**Consultation Response from Alan Smith,
KC Waste Strategy (Refuse & Recycling)**

2025/93480 Land off Parkwood Road/Weavers Lane, Longwood, Huddersfield, HD3 4TT

Erection of 28 dwellings with associated landscaping and external works

Responding Ref: WPS 25 071

Site Waste Management Plan

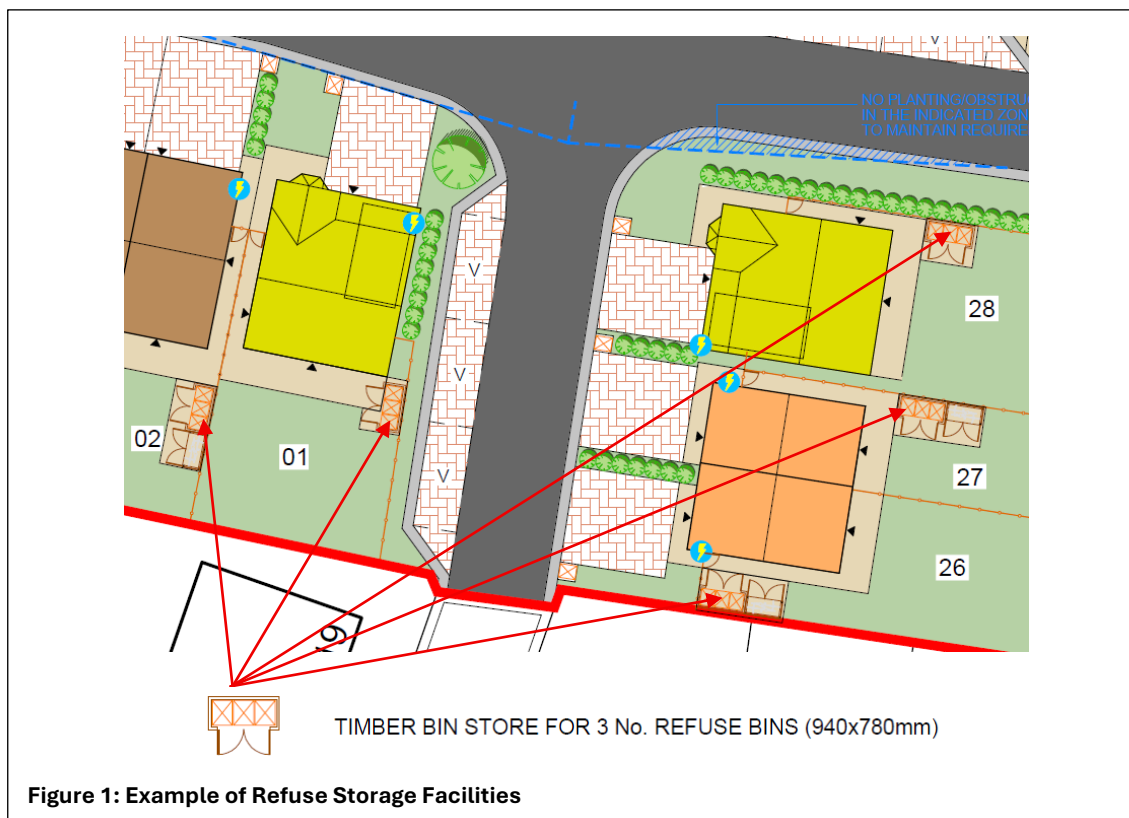
It is pleasing to see that a Site Waste Management Plan has been included which shows the bin storage point for 3 bins and bin collection point for each property.

- For all plots on the site if the distance from the bin storage point to the BCP is over 25m. Consideration needs to be given to providing these properties with a bin store located at the front of their property. Storage to the front of houses should be screened and avoid wheeled bins being left adjacent to doors and under windows.

Client				
MANDALE HOMES				
Project				
PARKWOOD ROAD, GOLCAR				
Title				
PROPOSED ROAD LONGITUDINAL SECTIONS				
Sheet Size	Original Scale	Designed/Drawn	Checked	Authorised
A1	AS SHOWN	MF	WF	WF
Status	Drawing Number	Date	Date	Date
S2	25016-LE-00-ZZ-DR-C-0003	26.06.26	26.06.26	26.06.26
Rev				P02

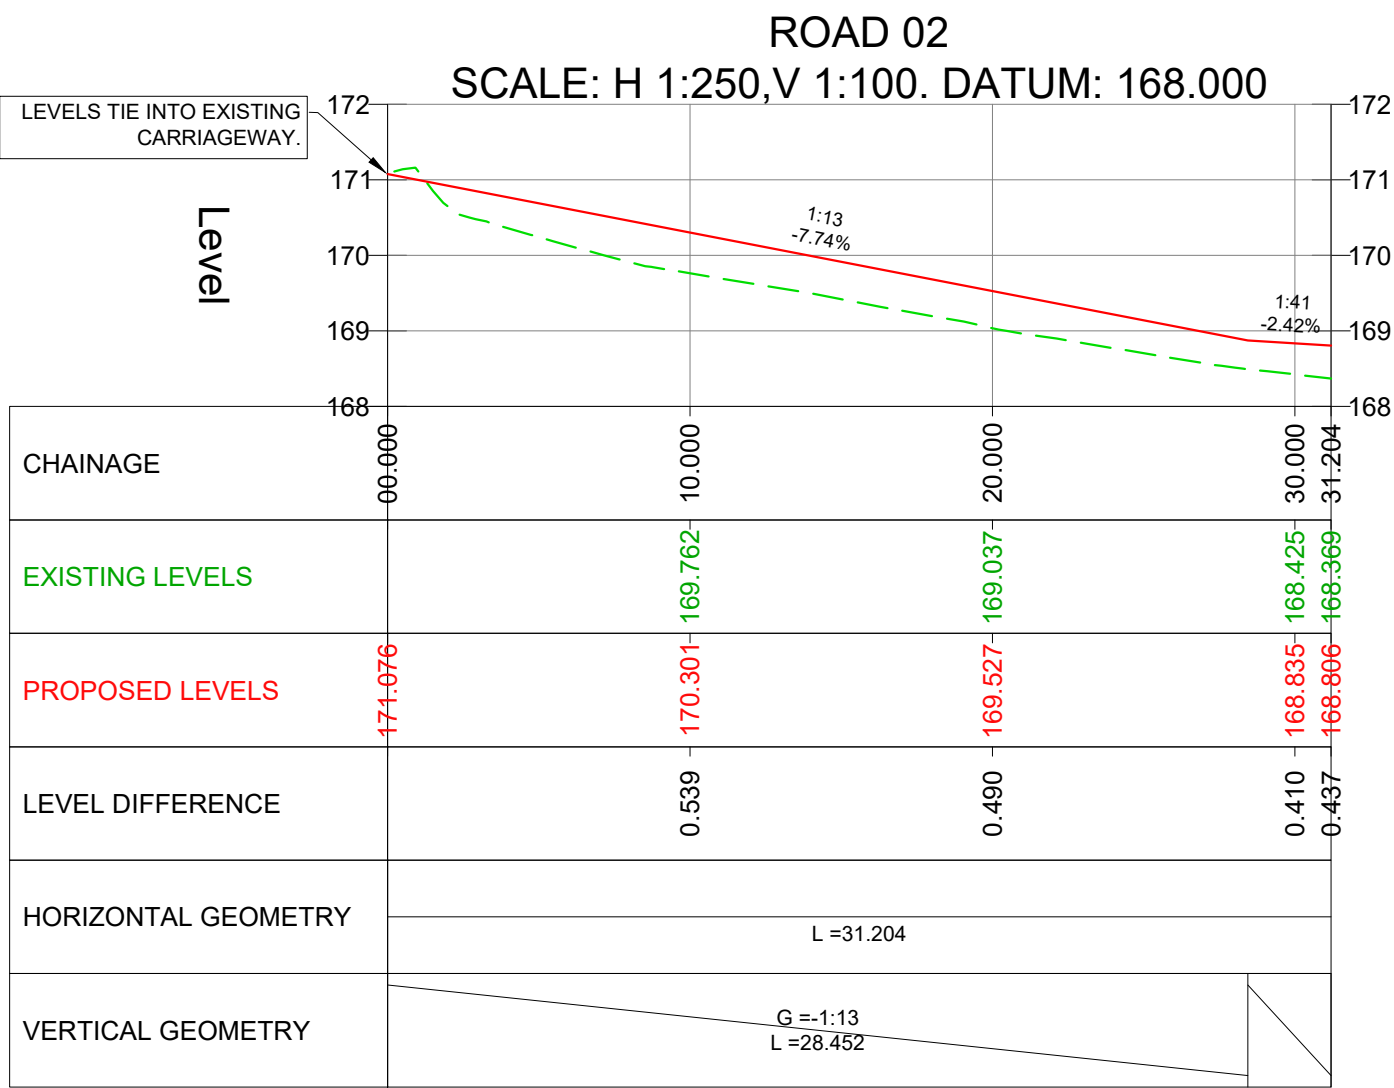
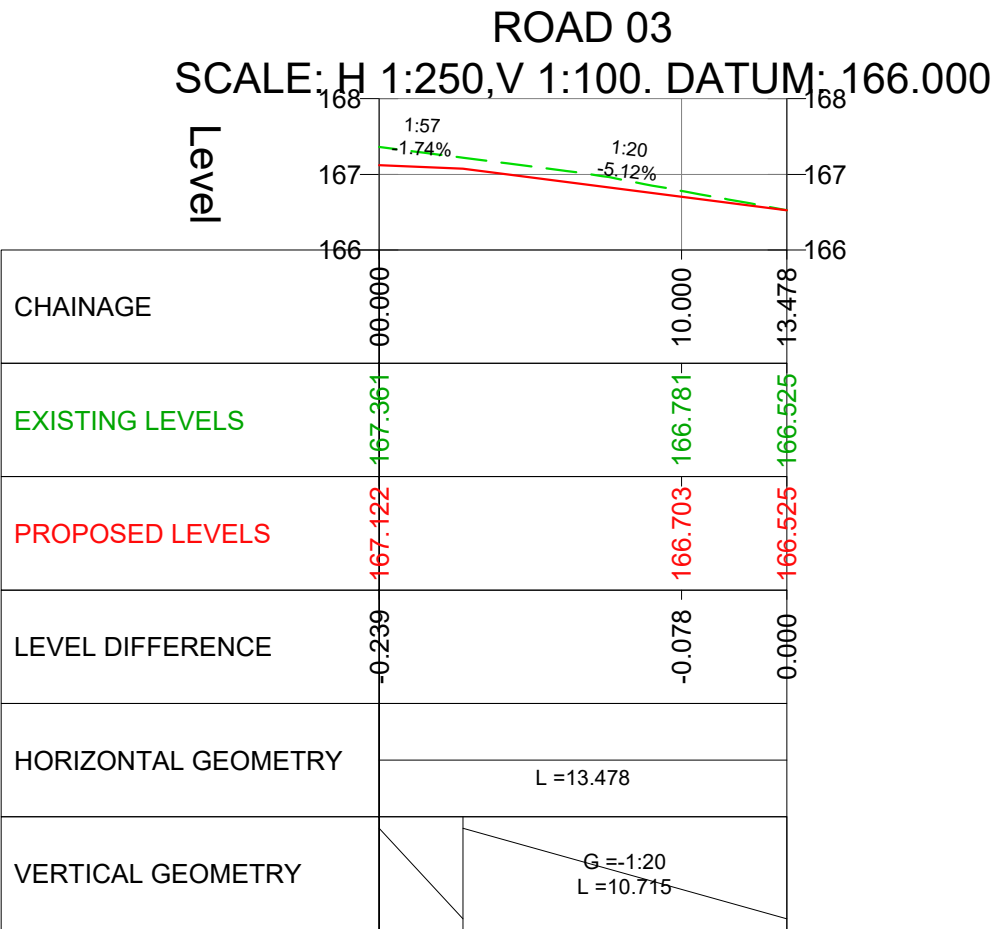
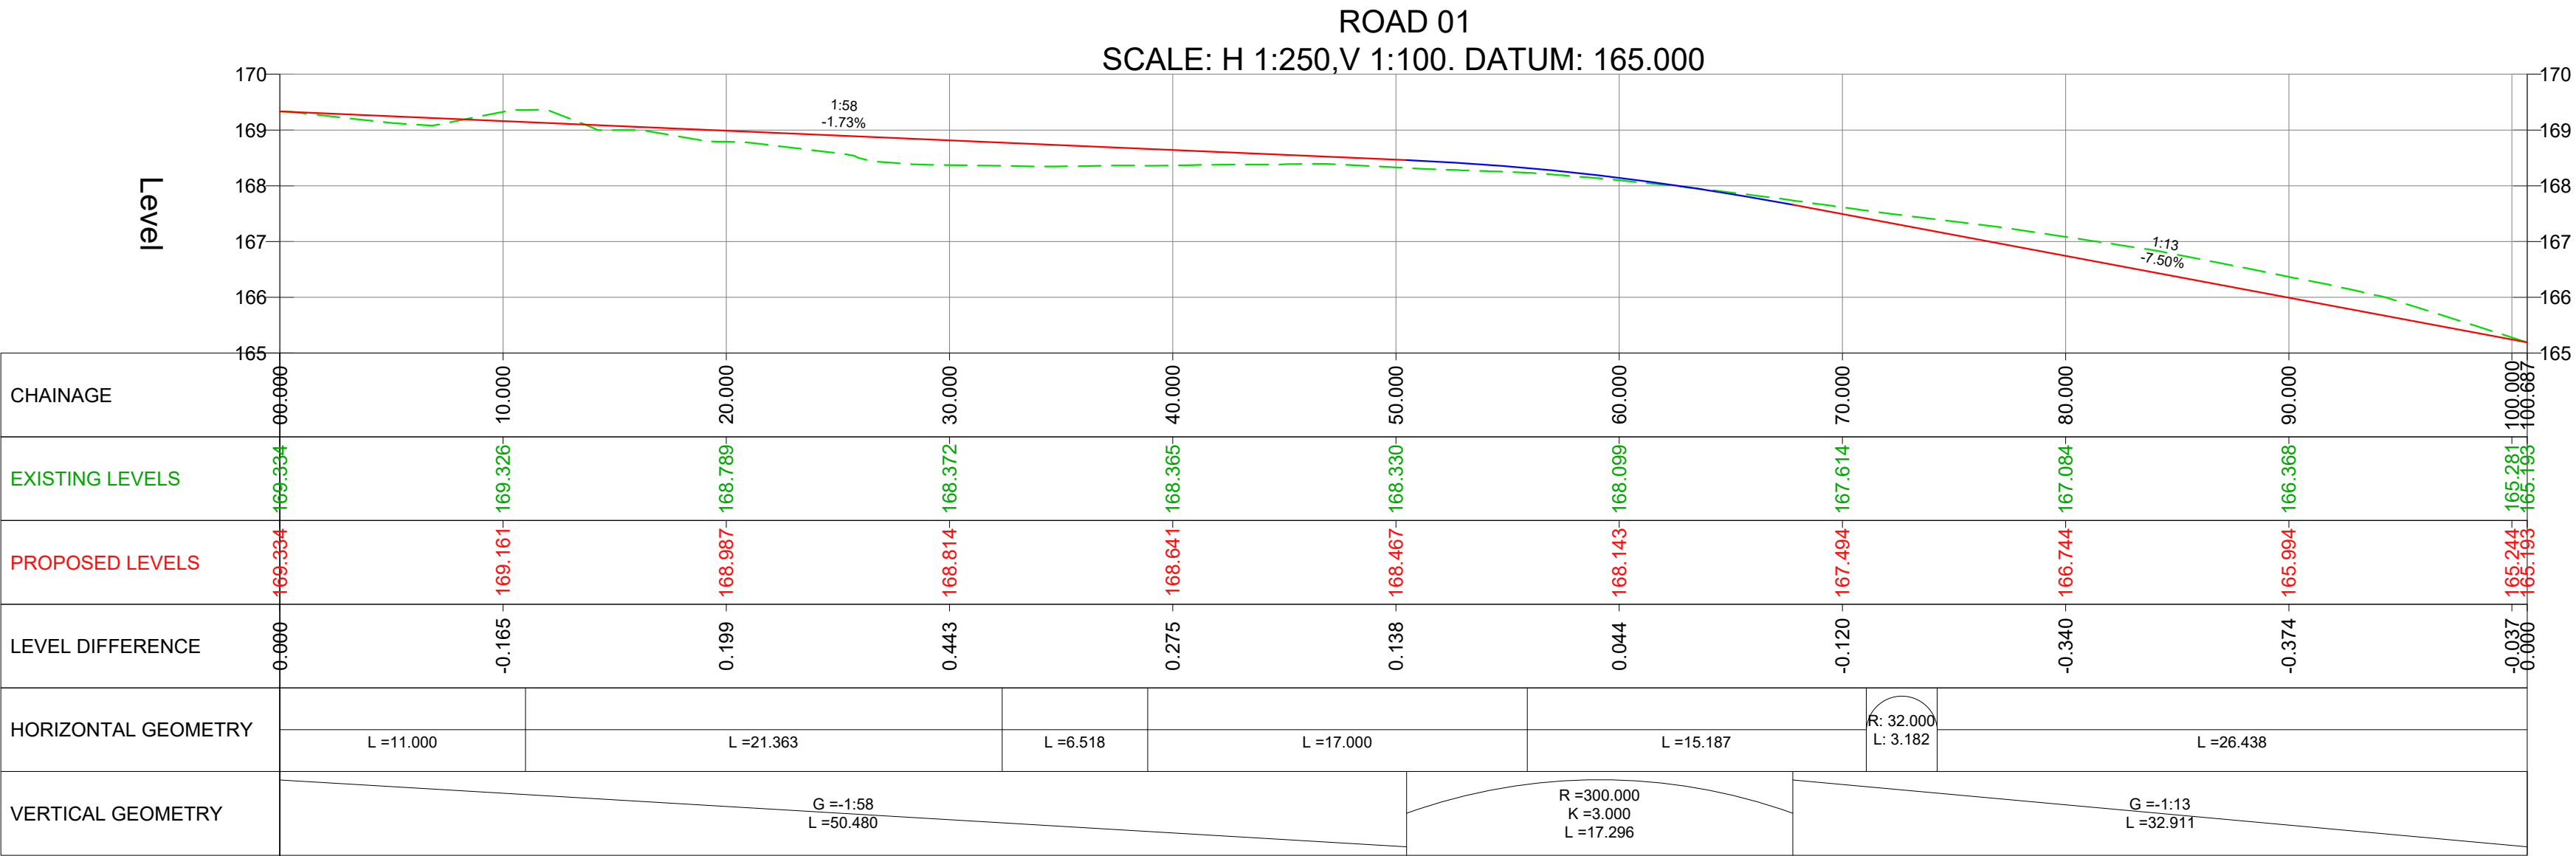
- The WCA will not enter:
 - Private drives
 - Roads not built to an adoptable standard
 - Active construction sites
- Road layout must:
 - Enable looped access (preferred over cul-de-sacs)
 - Where applicable, turning heads must be suitable for an 11.85m RCV
 - Turning areas must be made active to avoid them being used for additional parking
- Reversing distance for an RCV must not exceed 12m (WISH guidance)
